**November 23, 2020**

**REQUEST**

Douglas BNB, LLC requests an amendment to the approved special use permit (PCD File No. AL-09-002) to modify existing and approved uses under the permit allowances and site plan. The amended request includes:

THE HIDEAWAY: RECREATION CAMP/RETREAT CENTER
Colorado Springs, CO
SPECIAL USE SITE PLAN MAP

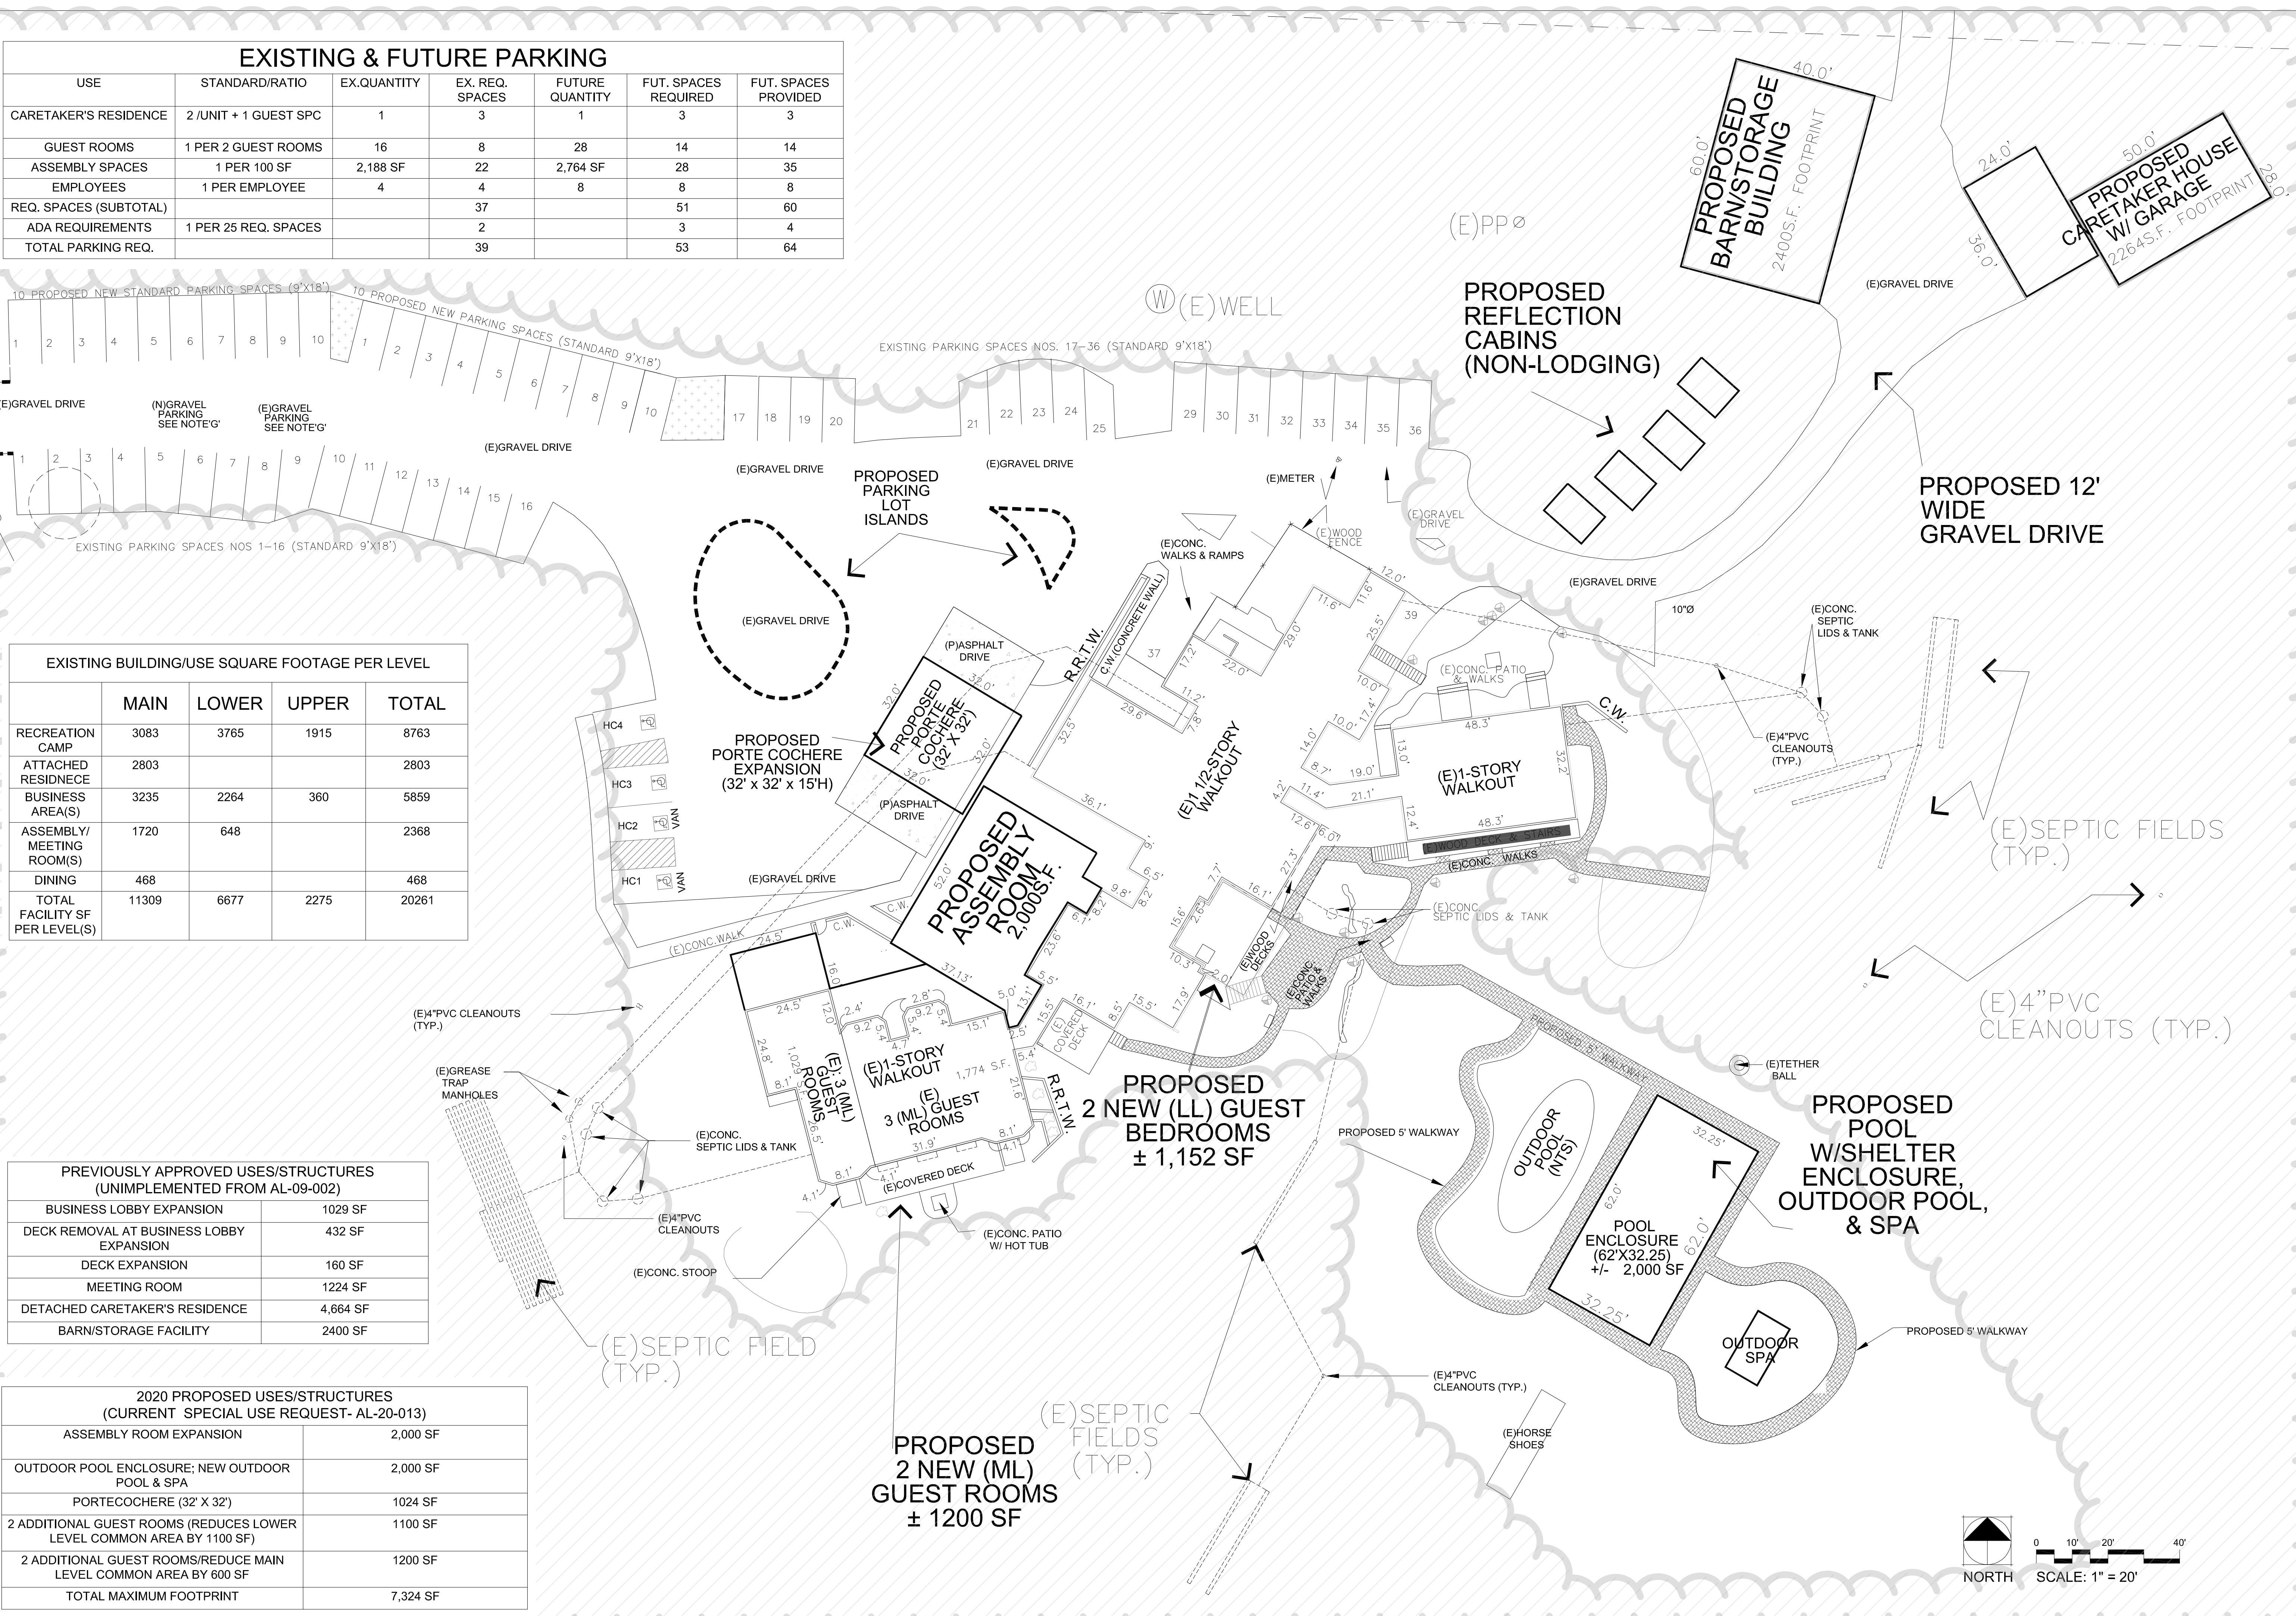
If parking lot is not to be paved, please explain how parking spaces will be denoted? Will there be wheel stops to mark them or just informal? Please see related redlines on plan at location of accessible parking.
